## LBH-PM-191105

### LBH RESIDENCE PROJECT MEMO

*Project:* 7450 N Mercer Way  
Mercer Island, Washington 98040

**RE: PERMIT NUMBER: 1904-048  
POST-PERMIT REVISIONS APPLICATION**

2 ZONING DIAGRAM - Gross Floor Area (GFA) Diagrams & Summary
Scale 1" = 20'

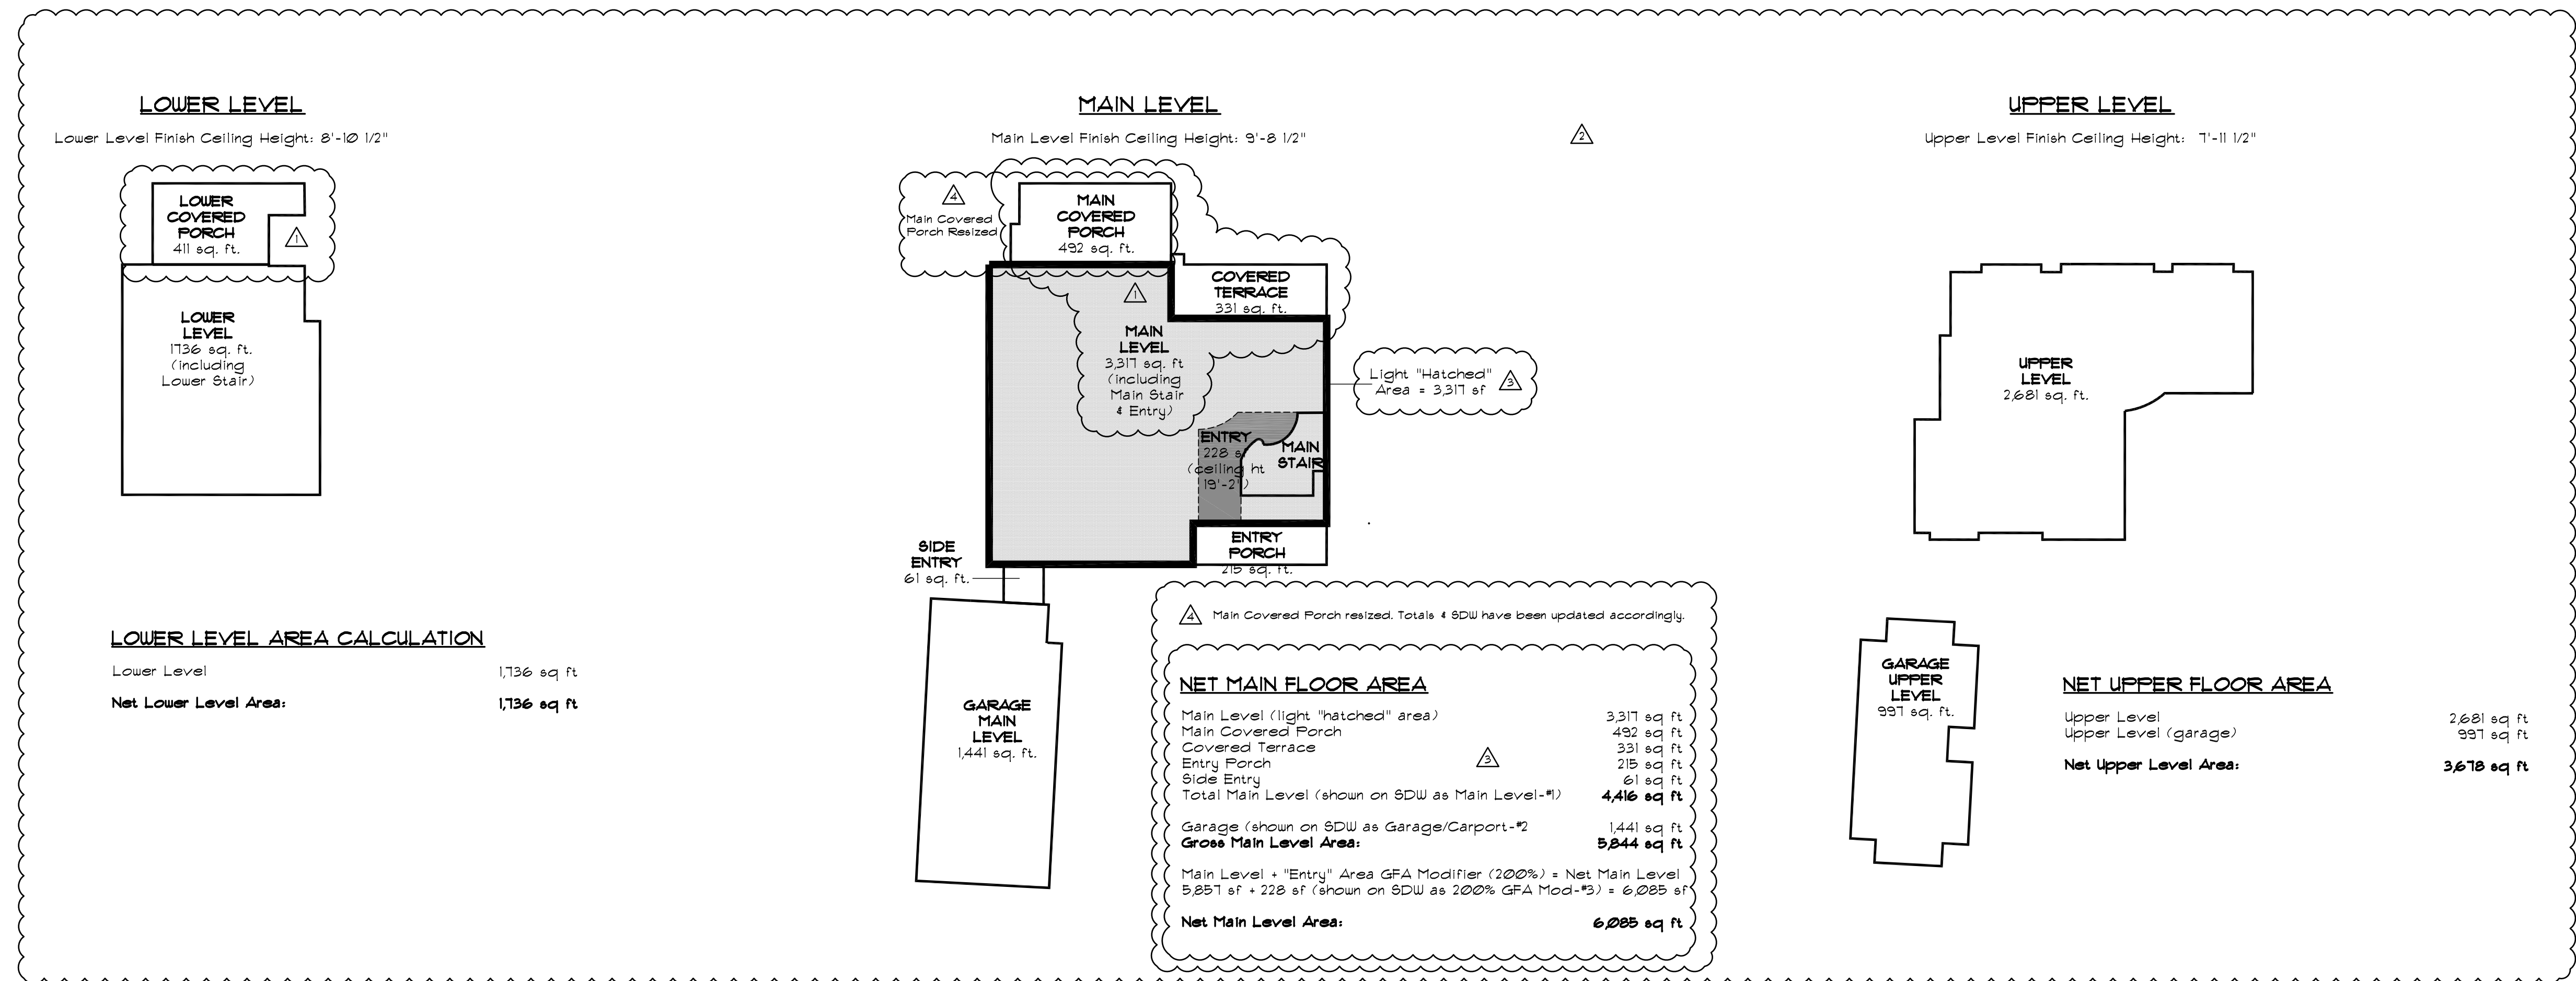
Site Plan changes noted above have been updated on Detail 1 (ABE) and Detail 2 (GFA). Average Building Elevation (ABE) calculations & findings remain the same. Main Level Gross Floor Area (GFA) diagram and calculations have been updated to reflect the revised Main Covered Porch. Site Development Worksheet has been updated accordingly.

A-1.3

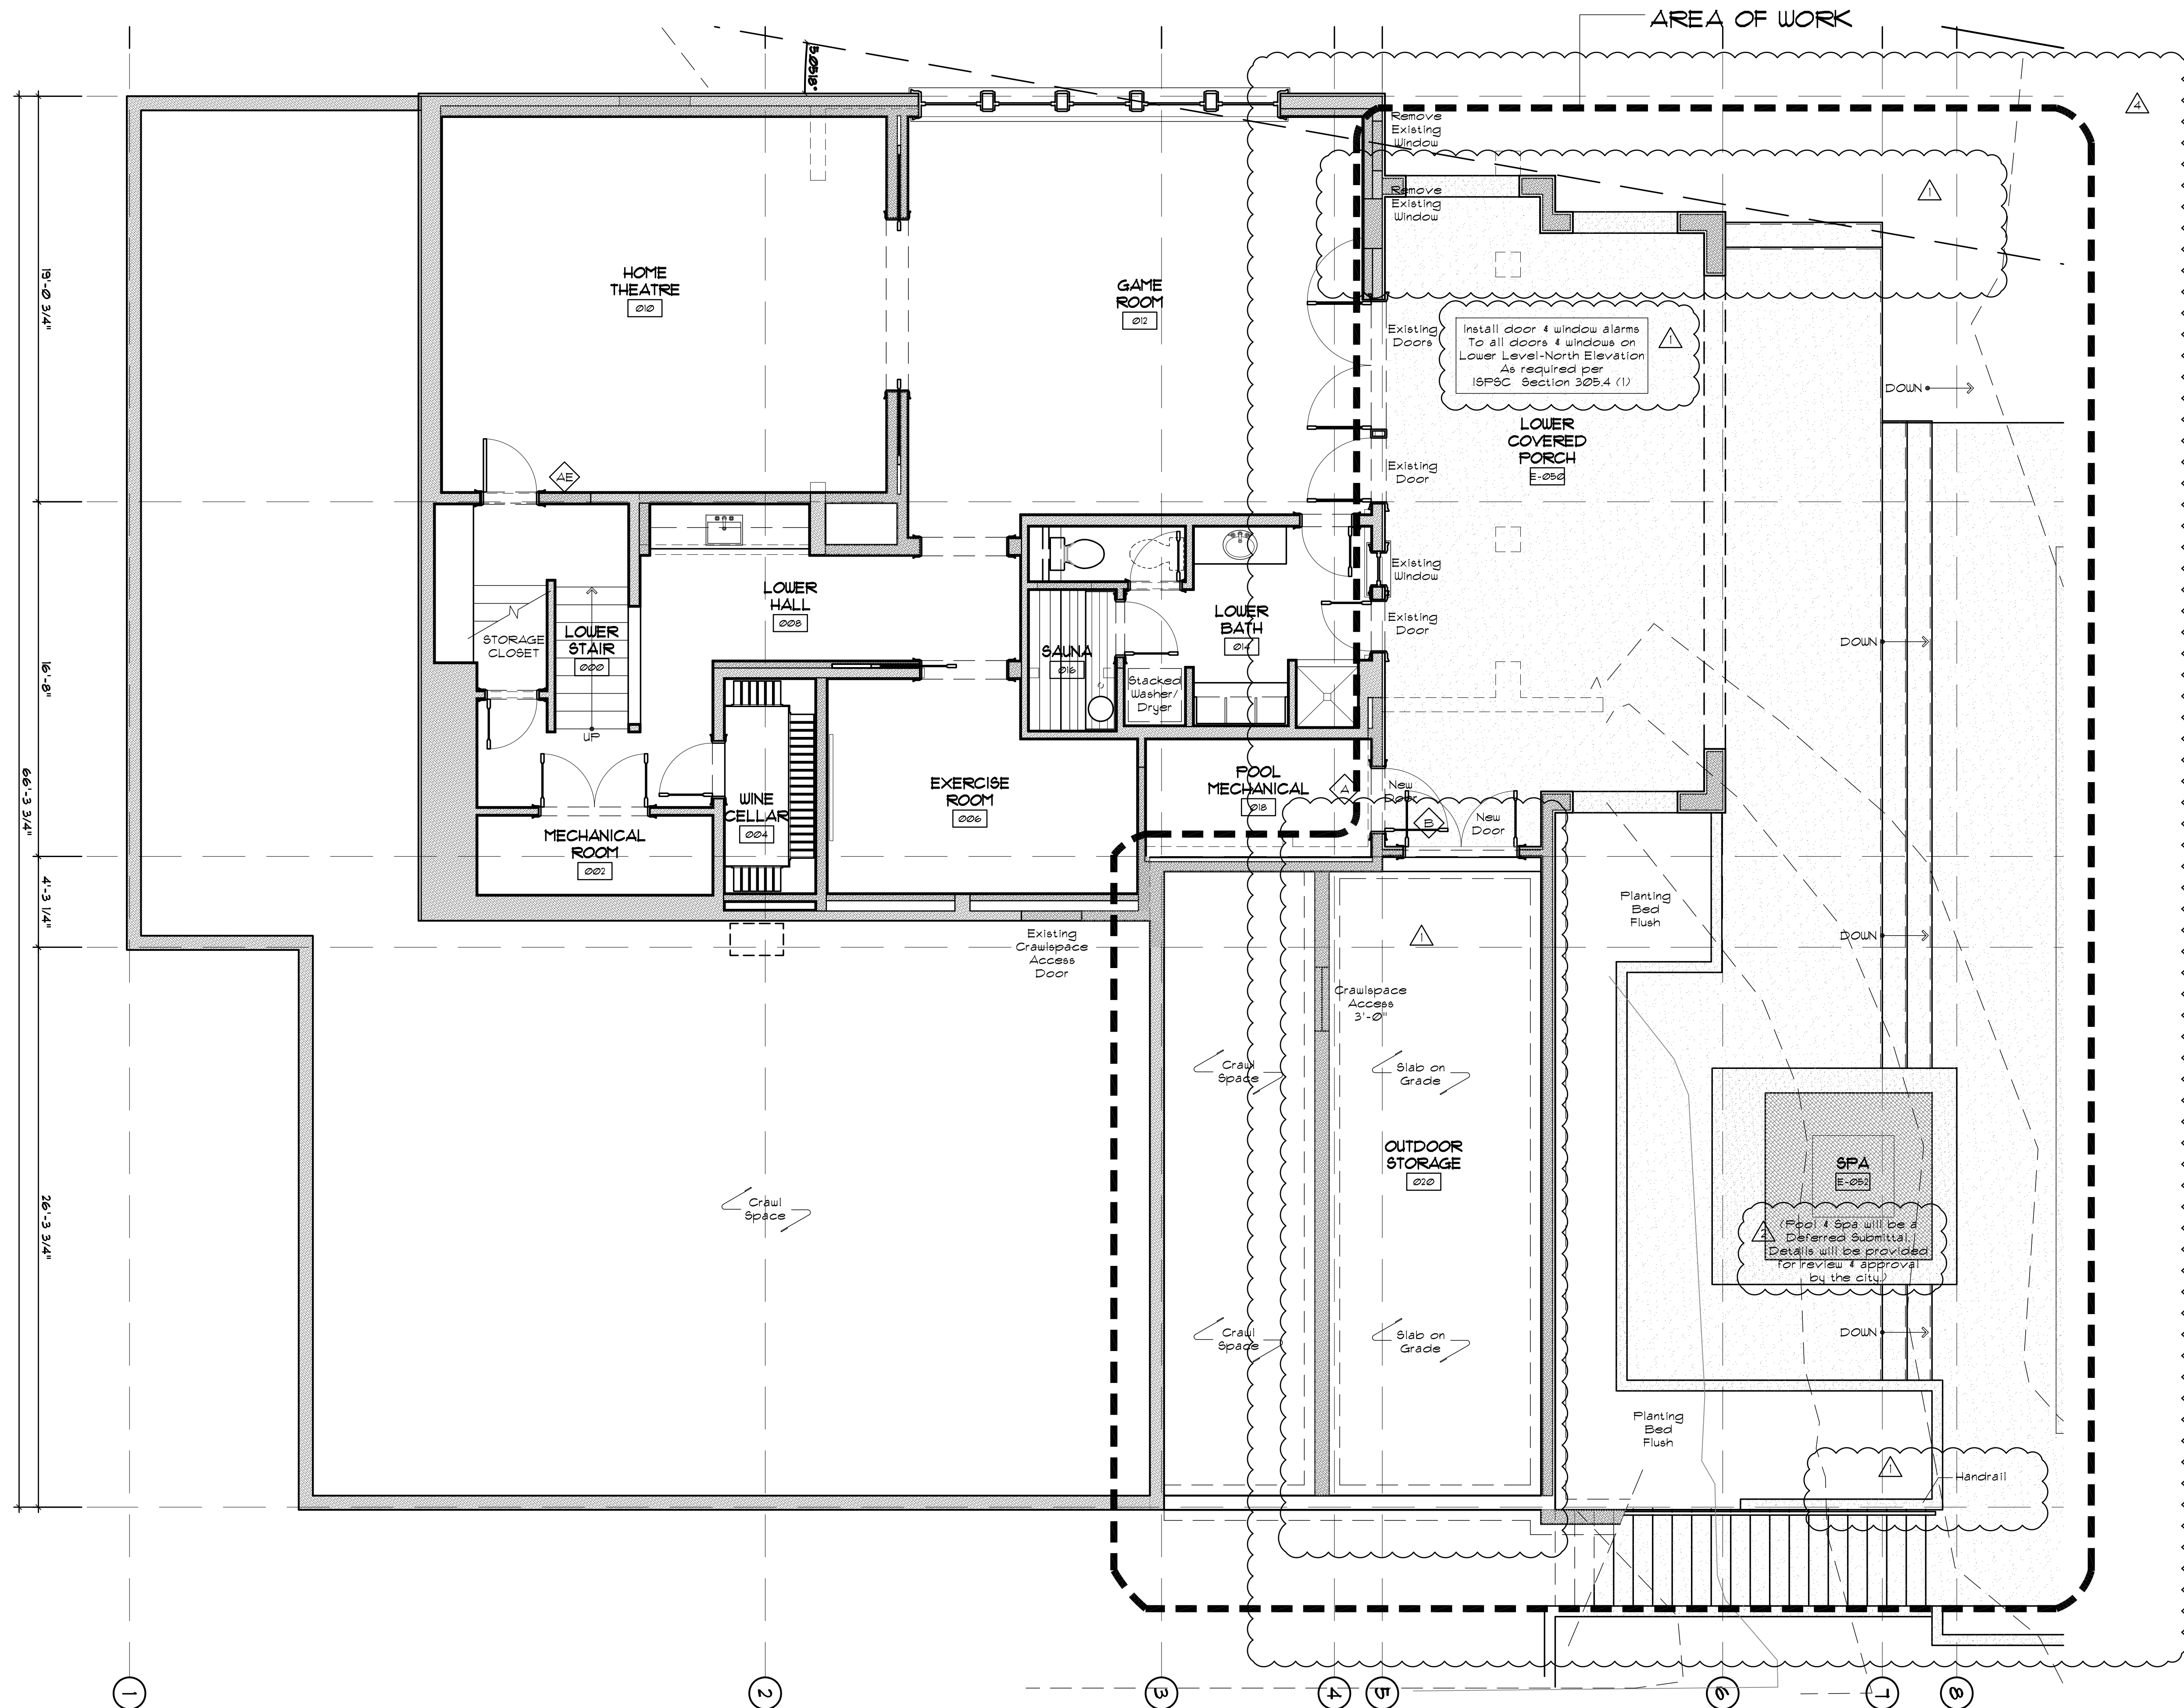
Diagrams and calculations have been updated to reflect revised Main Covered Porch, reconfigured Pool Stair, Pool & Terrace layout, and elimination of concrete pavers at shoreline. Site Development Worksheet has been updated accordingly.

A-2.1

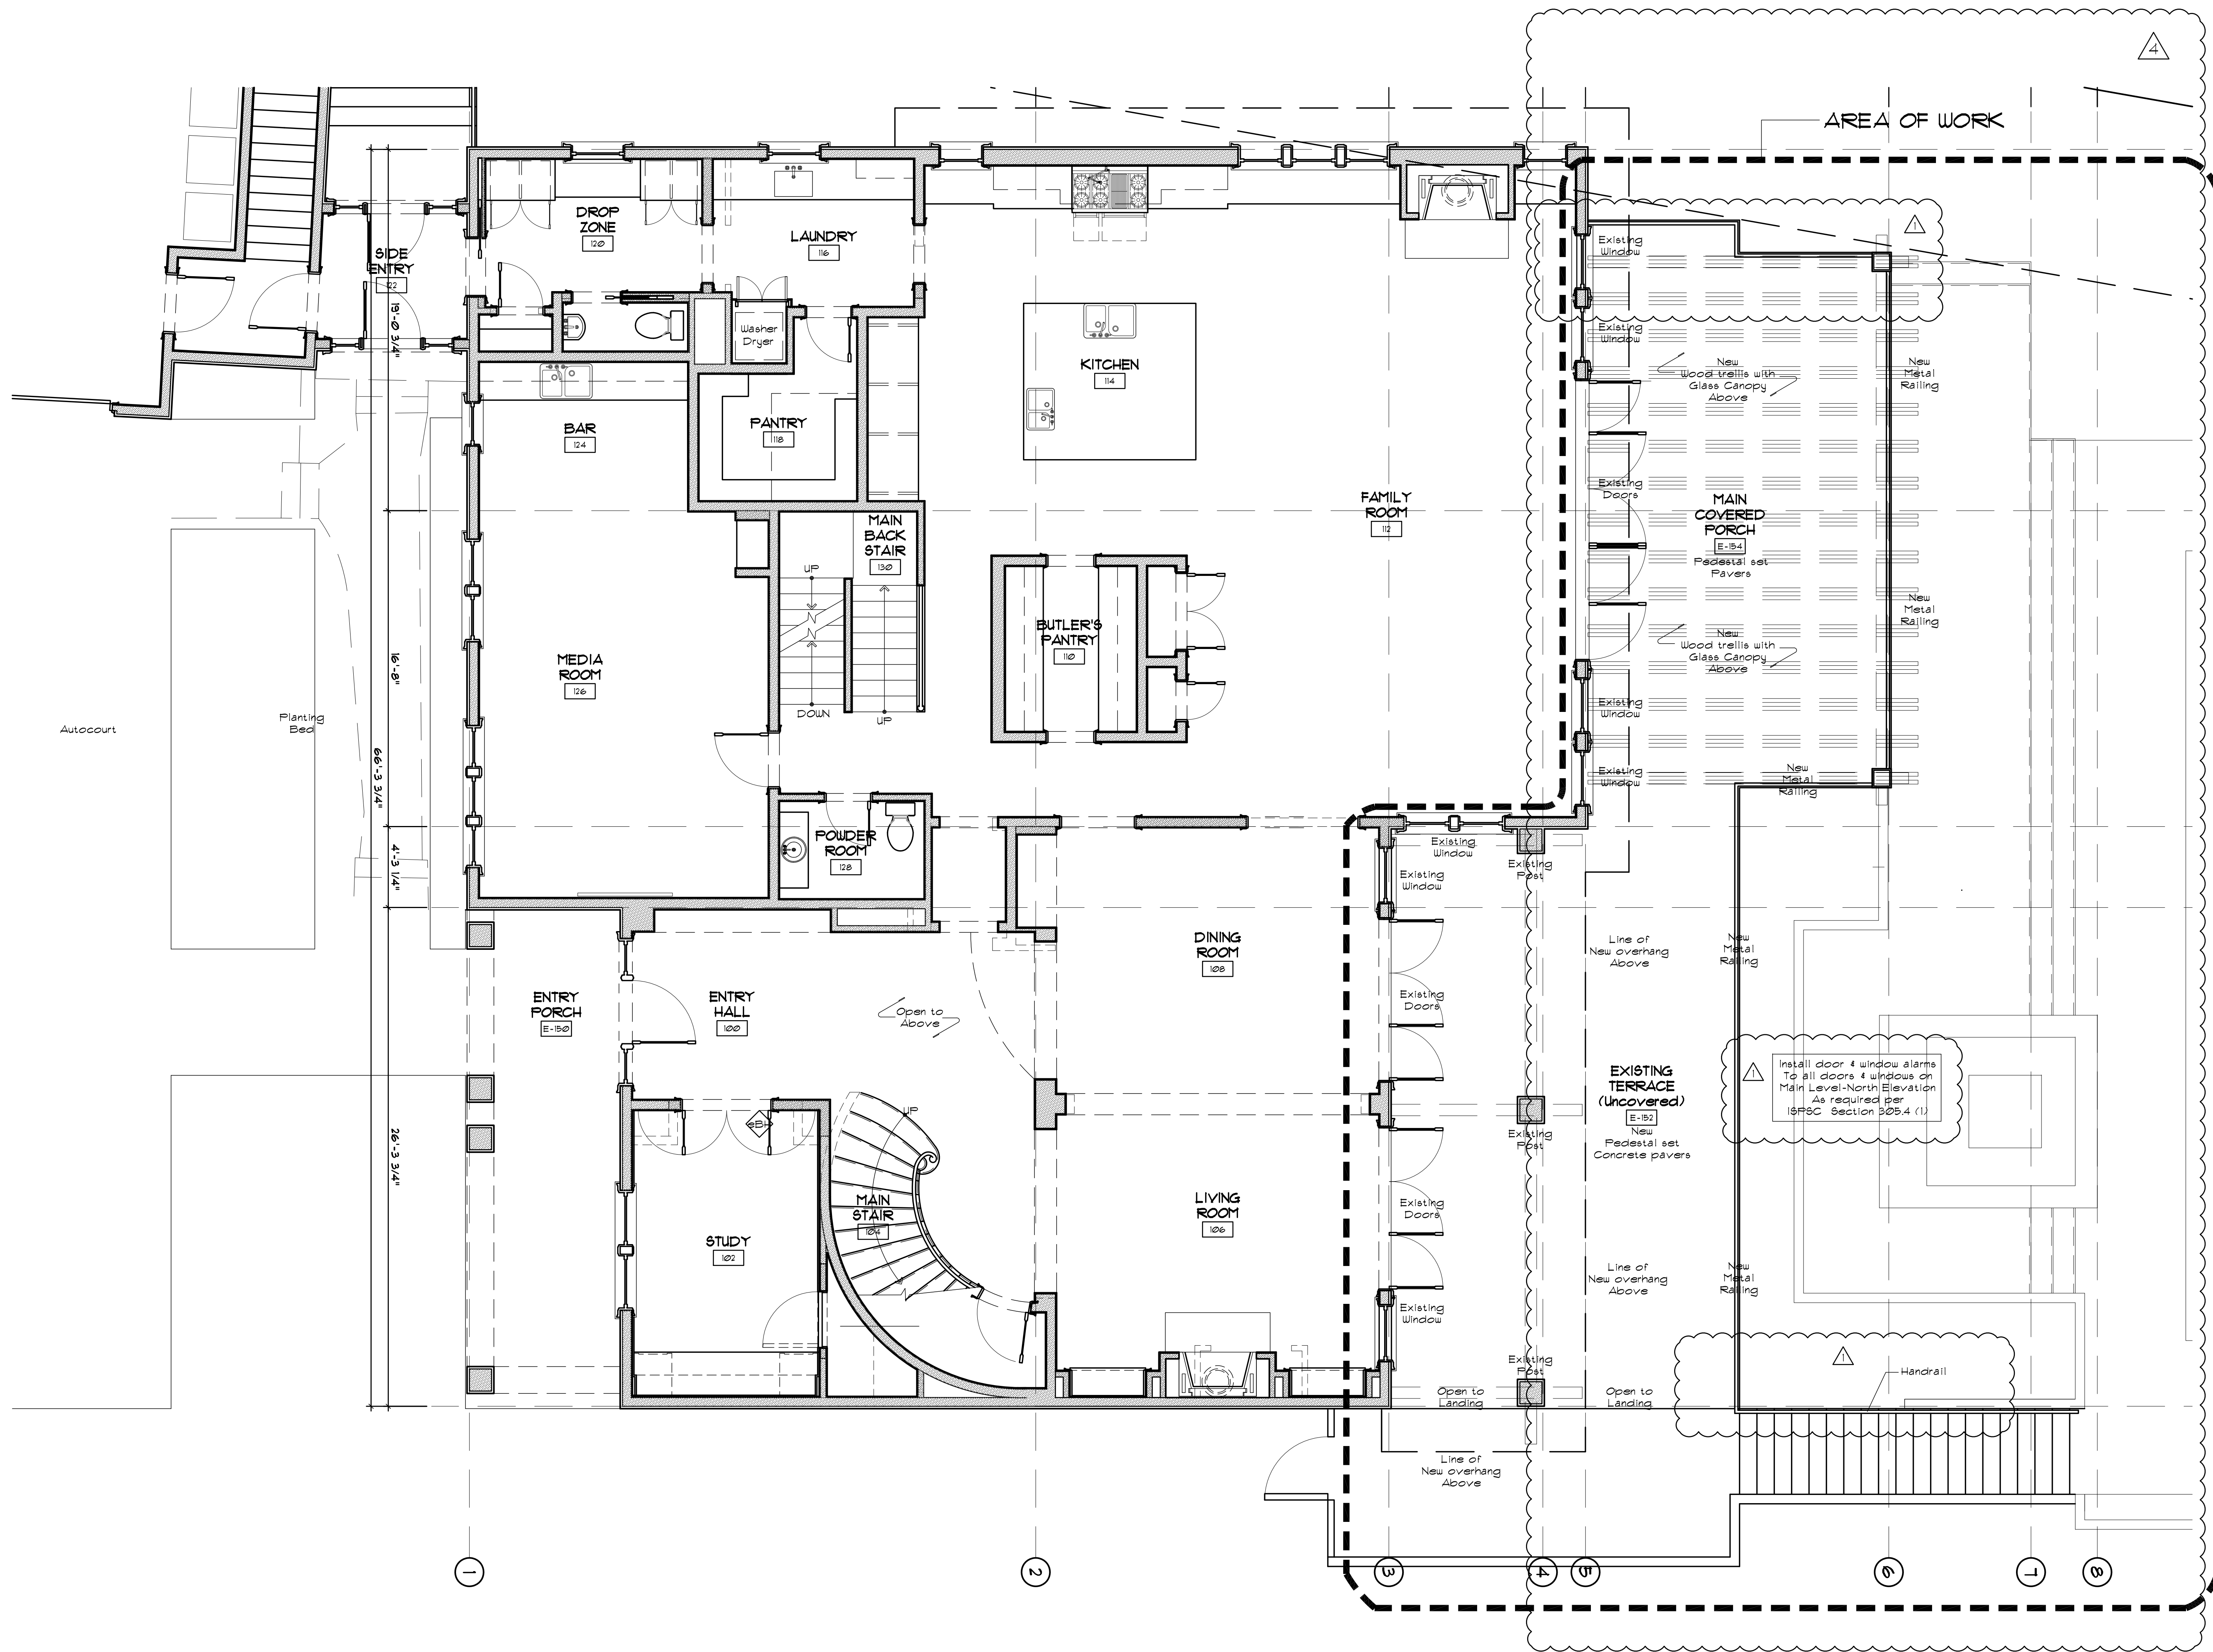
Lower Covered Porch has been revised. Door B to Outdoor Storage has been revised from a single door to a pair of doors. Pool Stair has been revised.
